Hans Wittler Automotive, 121 Elizabeth St. NE, Traffic Circulation Layout, Architect's Stamp dated 3-5-14 (K21-D034)

RE: Hans-Wittler Auto Addition, 121 Elizabeth St. NE Grading and Drainage Plan for Building Permit

Subject: K21-D034 Hans-Wittler Automotive Addition - 6/17/13 Seal Date

Subject: RE: K21-D034 = Hans-Wittler Automotive Addition (8/22 draft revision)

GRADING & DRAINAGE PLAN

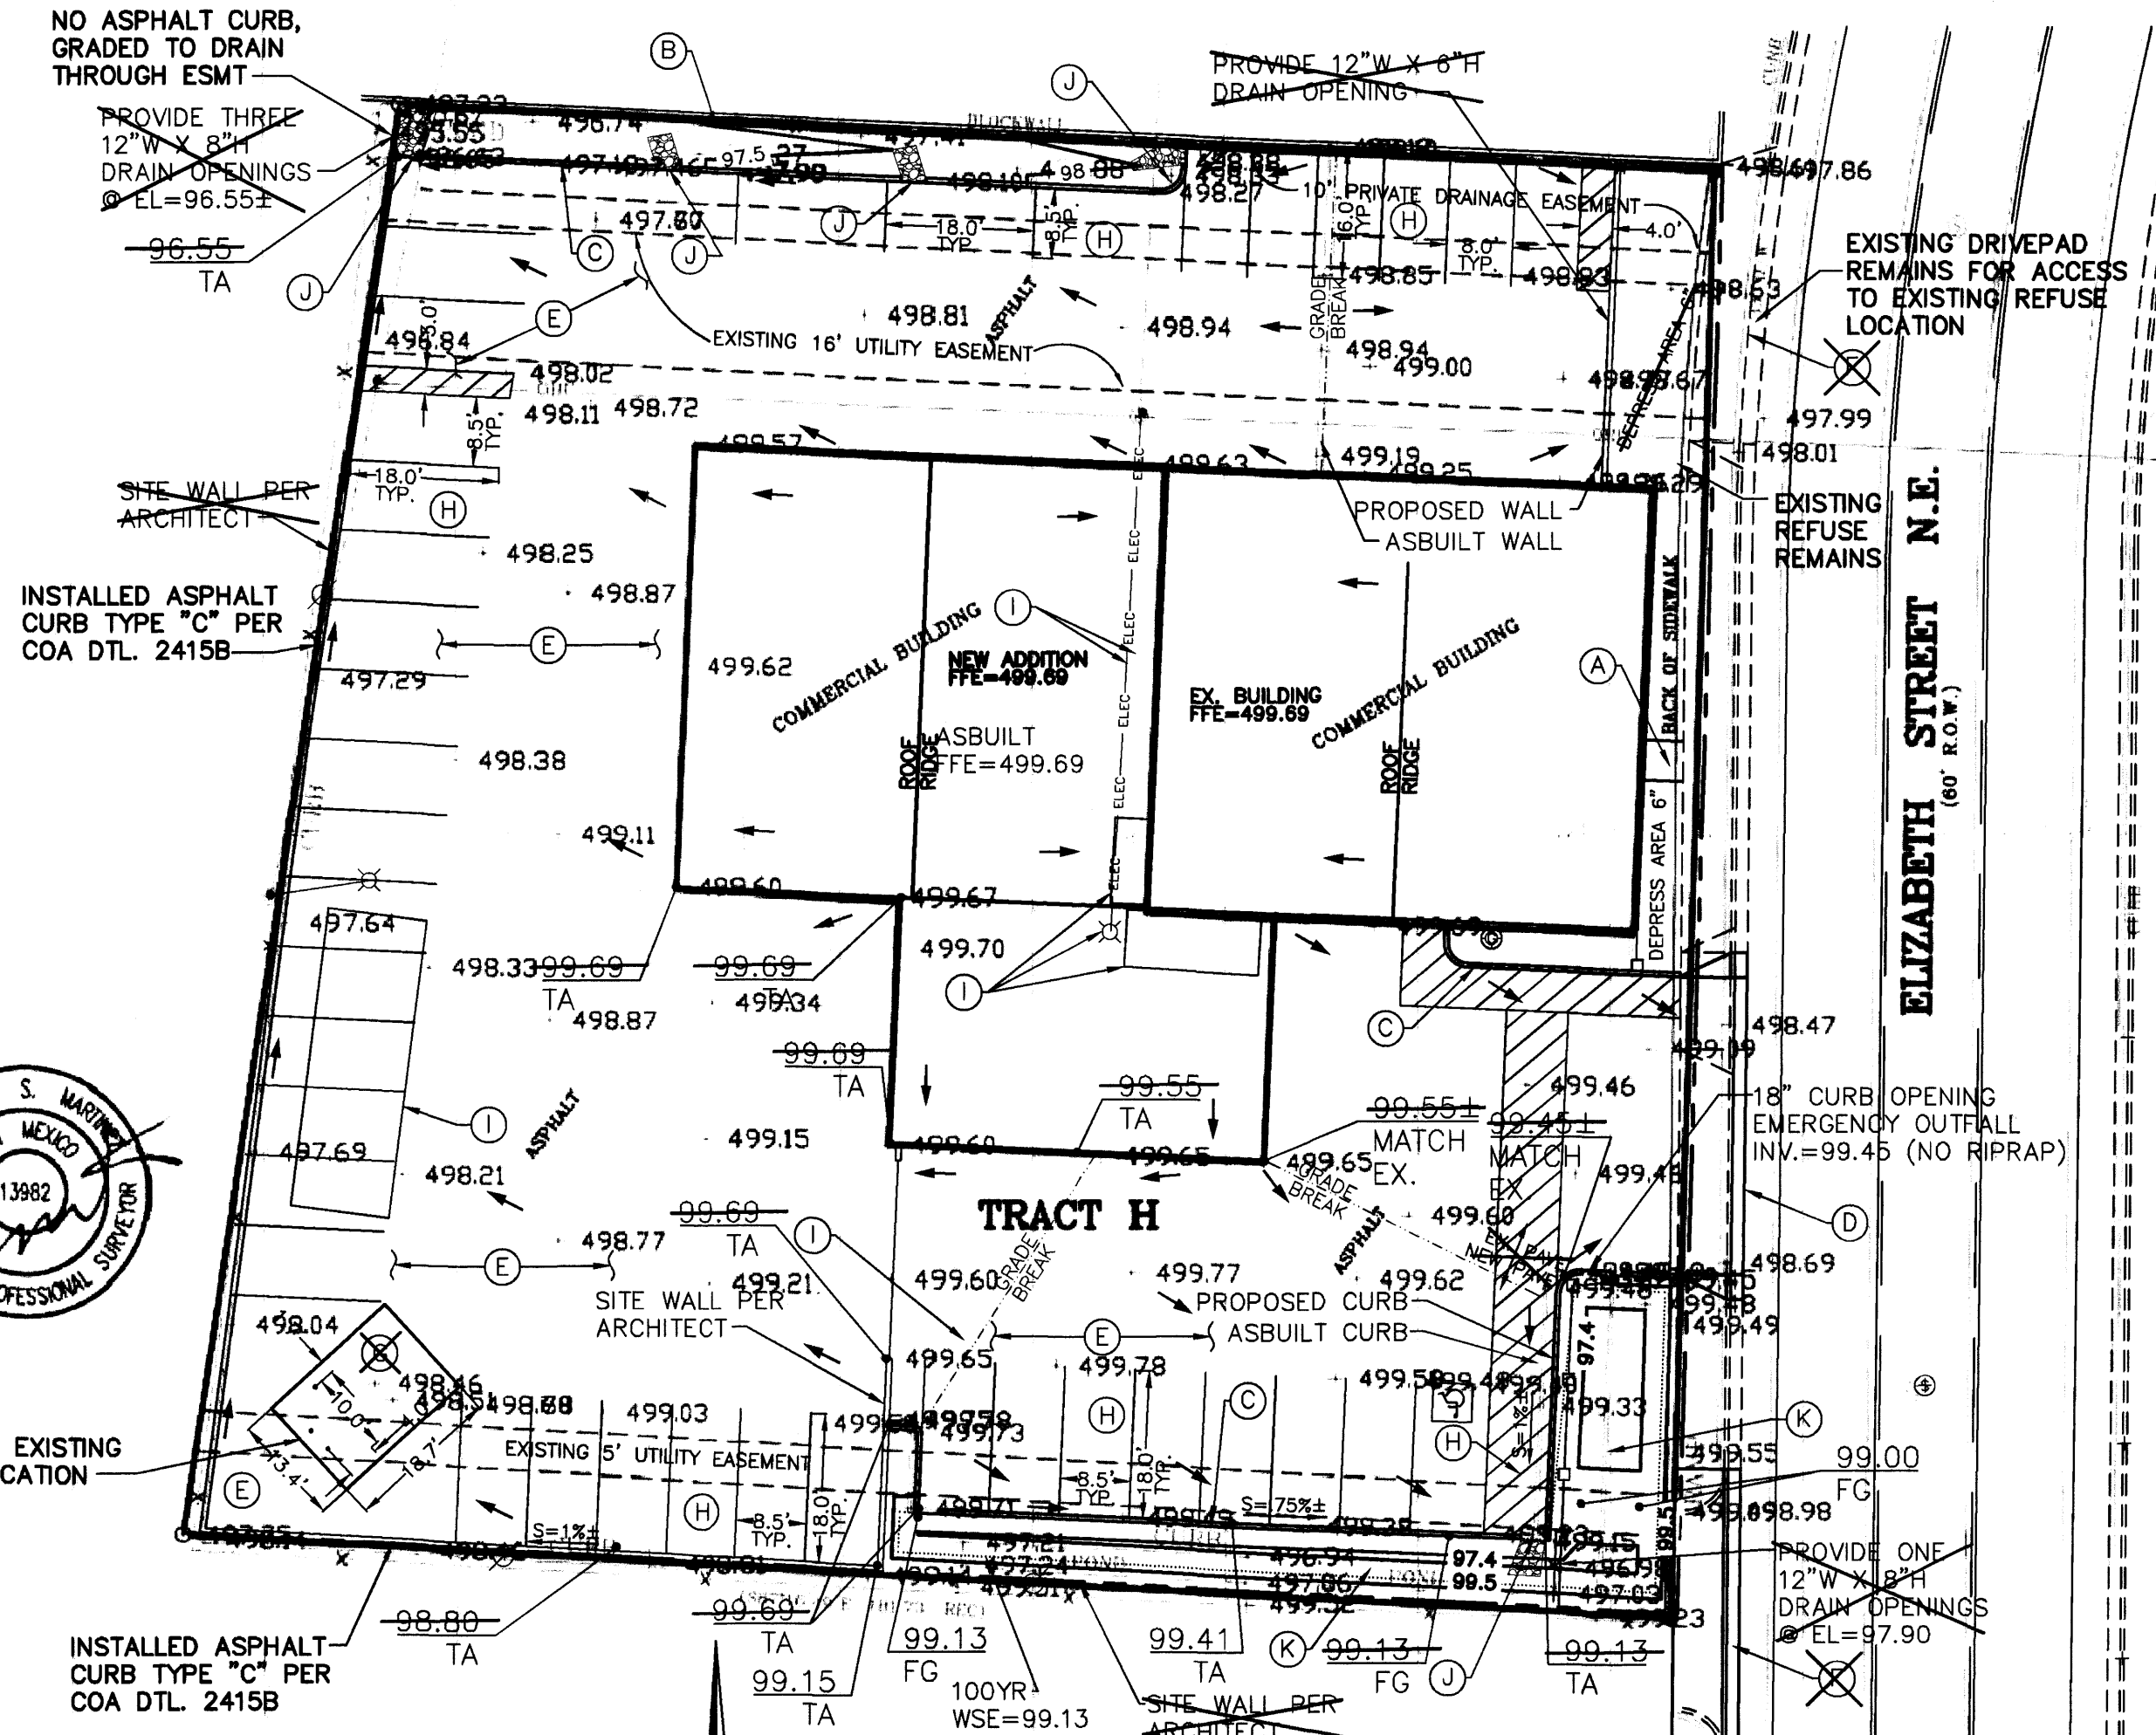
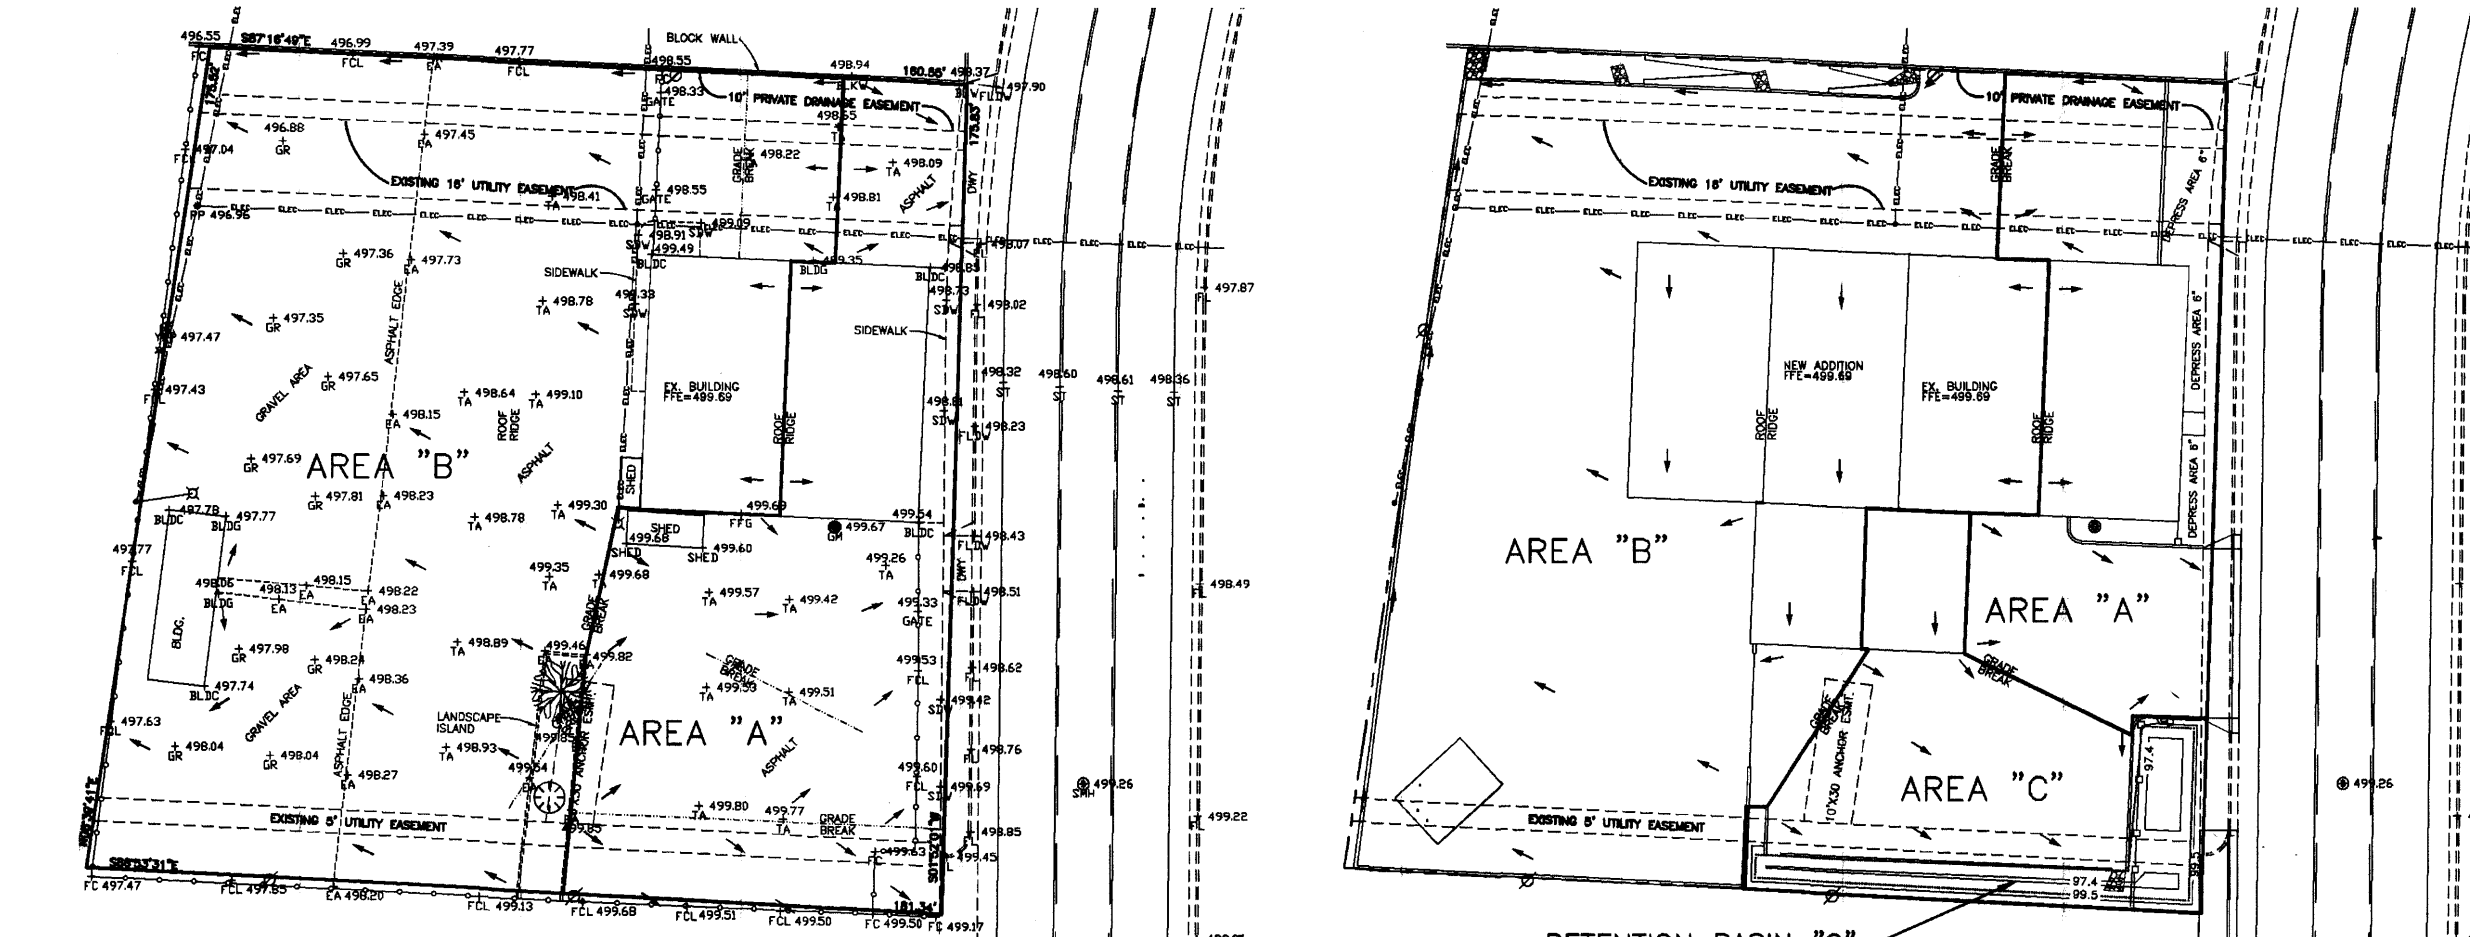
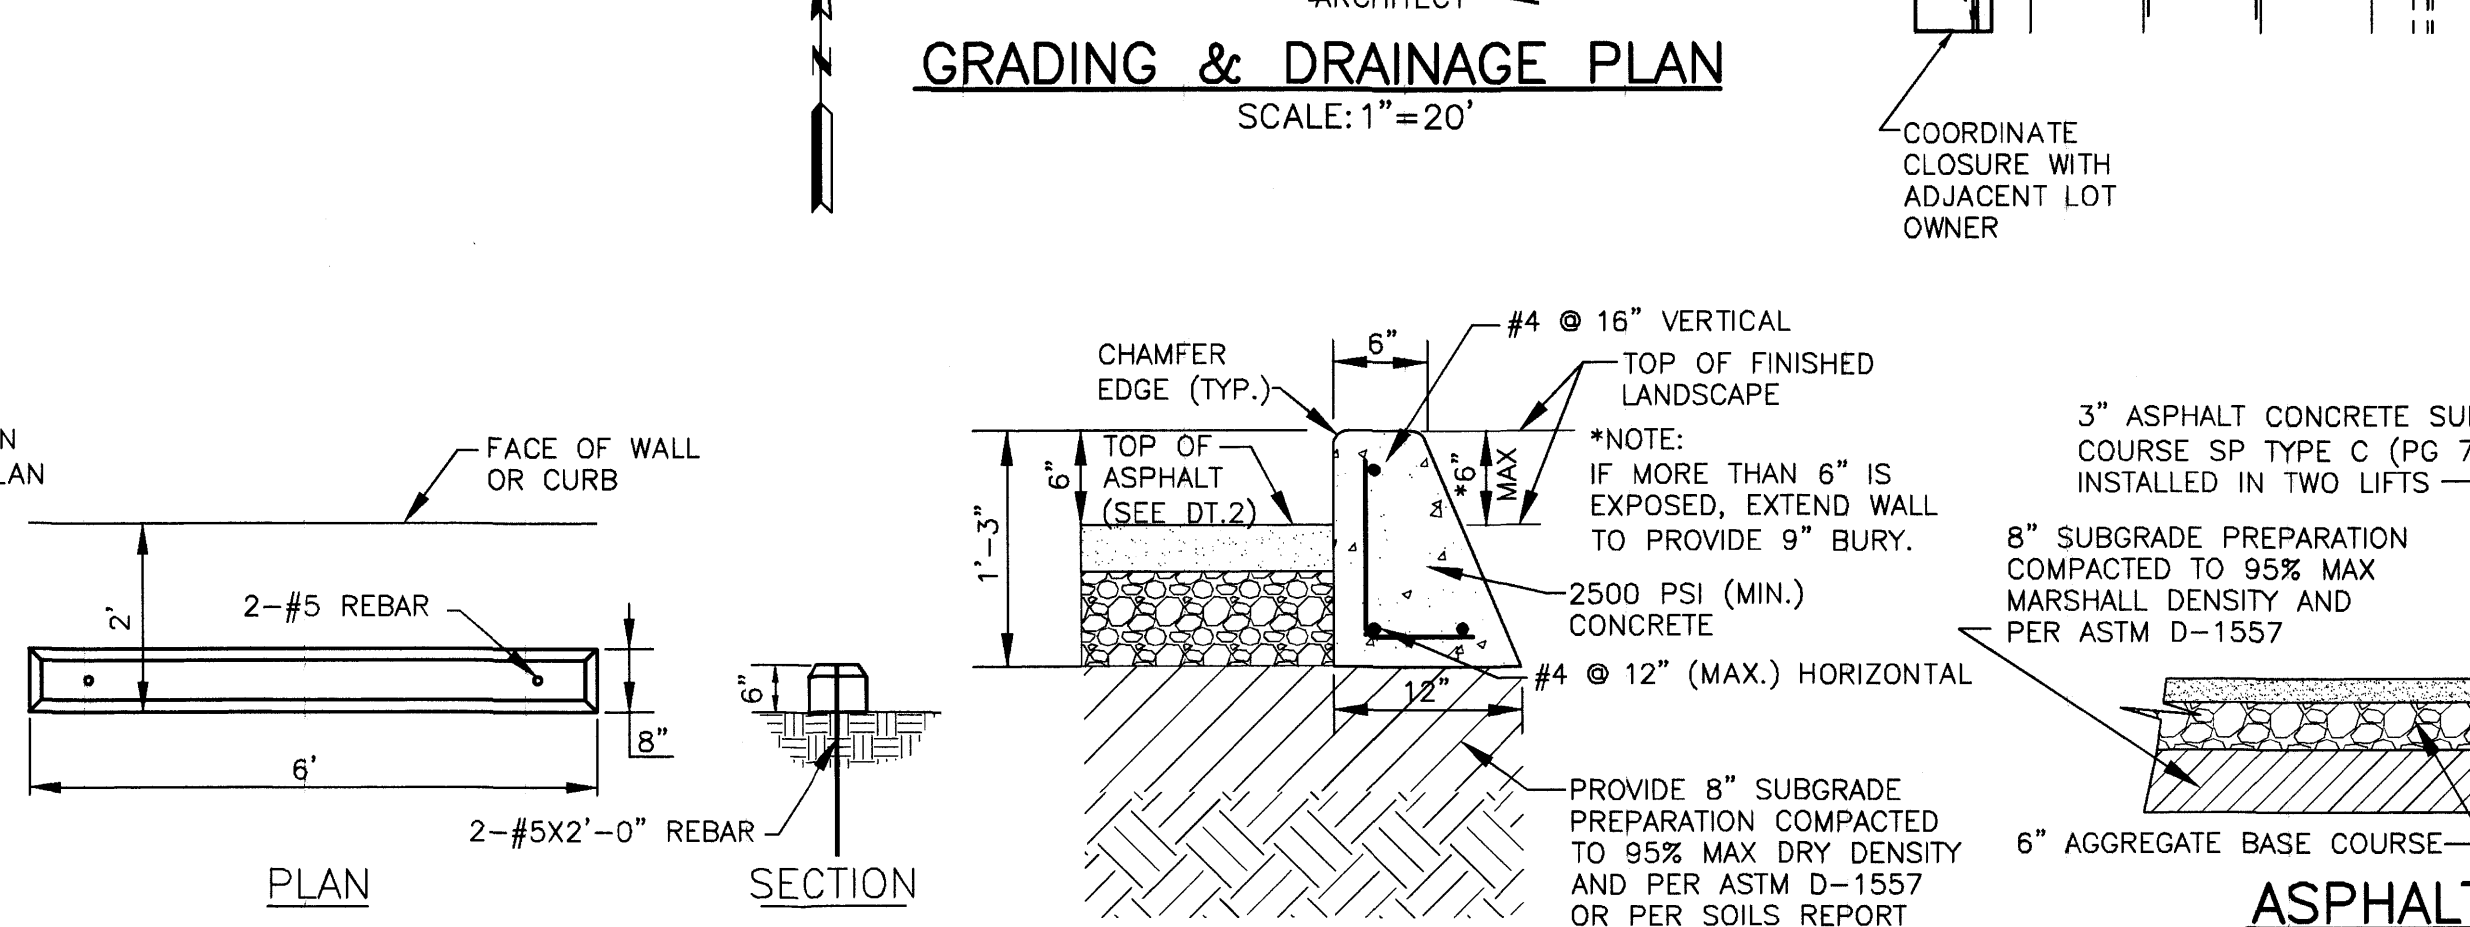
1. Pond Volume: I have been using the average end area method, scaling areas at the 97, 98, 98.6, and 99 contours. I did another, more careful area take-off, and still only come up to 807 cf, vs. required 913 cf). A significant loss occurs where the berm cuts through the pond at elev. 98.6, coincident with the 5' utility easement. Also only 1-foot depth on the westerly portion reduces the capacity. If you can get more capacity, that would be ideal. If not, I think the routing of flows through the pond to an "emergency overflow" to Elizabeth St. (see comments 3 and 4 below) will adequately resolve this point.

More grades need to be provided at the SE corner of the pond, where the existing drive pad is proposed to be closed, including some back of sidewalk grades along the property (pond) boundary.

Will a header curb/wall be required along part of the south edge of the pond to build up the grades where the existing, adjacent pavement on the lot to the south is lower (99.17)? My specific concern is to ensure that any pond overflow goes out to Elizabeth St. and NOT onto the lot to the south.

A. Show how excess flows from the pond will overflow to the street. It looks like the existing grades near the N end of the pond may facilitate an overflow point that would allow the "Emergency Overflow" from the pond to drain down the reconstructed driveway entrance at the NE corner of the pond. To prevent street flows from backing up into the pond, it is necessary to keep that overflow grade top of curb, or at least 8" above street invert, unless you can demonstrate that street flows will be less than that depth. This may necessitate raising the top of pond elevation. The plus here will be resolution of the volume concern discussed above.

1. The volume of the pond in Area C does not seem to total the 1,032 cf that you indicate. I get closer to 635 cf. The southern portion is only 1' deep.

- 2. Is the southeastern, 8' wrought iron, perimeter fence intended to be in the 2' deep retention pond?

The volume shown on the plan is derived from the Average End Area method. I've revised the calcs utilizing the Conic Approximation method. Result is slightly less at 921cf. Please let me know if there is another method you'd prefer.

Two additional curb opening have been added.

The fence has been moved back out of the pond. A portion of the block wall will be in the pond, however an opening will facilitate drainage.
- 3. Is it possible to route more of the Area B flows through curb openings to the northern swale, before discharging from the site?
